Our ref: P01348310

28 January 2021

**LAND ADJOINING AND WEST OF STONECROFT HOUSE, CLIFTON ROAD,
DEDDINGTON
Application No. 20/03467/F**

ELEVATION A-A - Entrance Wall and Gates Front Elevation
1:100

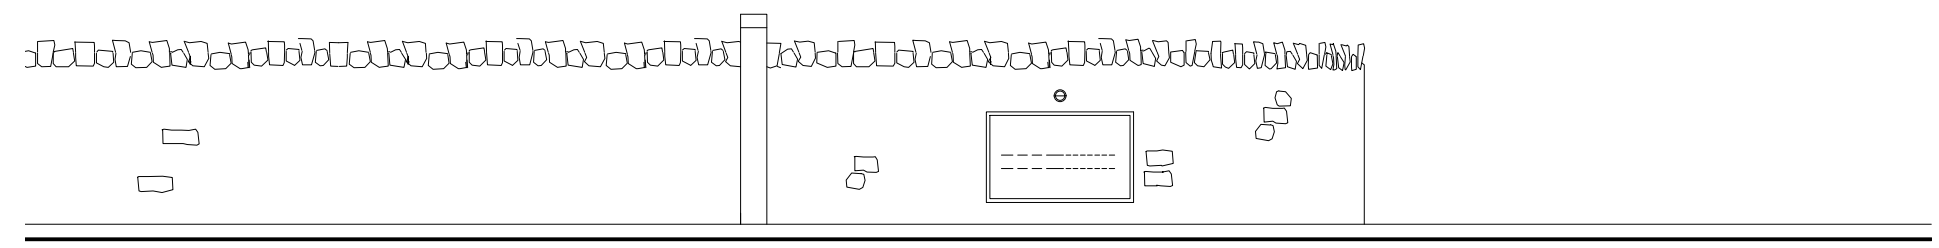
I note also that the applicant is offering to construct stone walls / planters at the entrance into the village along Clifton Road; to rebuild the stone wall along the edge of the Castle bailey and to maintain the open grassland of the undeveloped portion of the site as pasture. These are being offered as benefits to the heritage assets. While generally welcome, there is a stretch of proposed replacement chain link fence south of the development, on the edge of the castle site. A new stone wall here would complete the stone wall boundary around this part of the site and be an excellent benefit. I advise that the applicant should be asked to consider this.
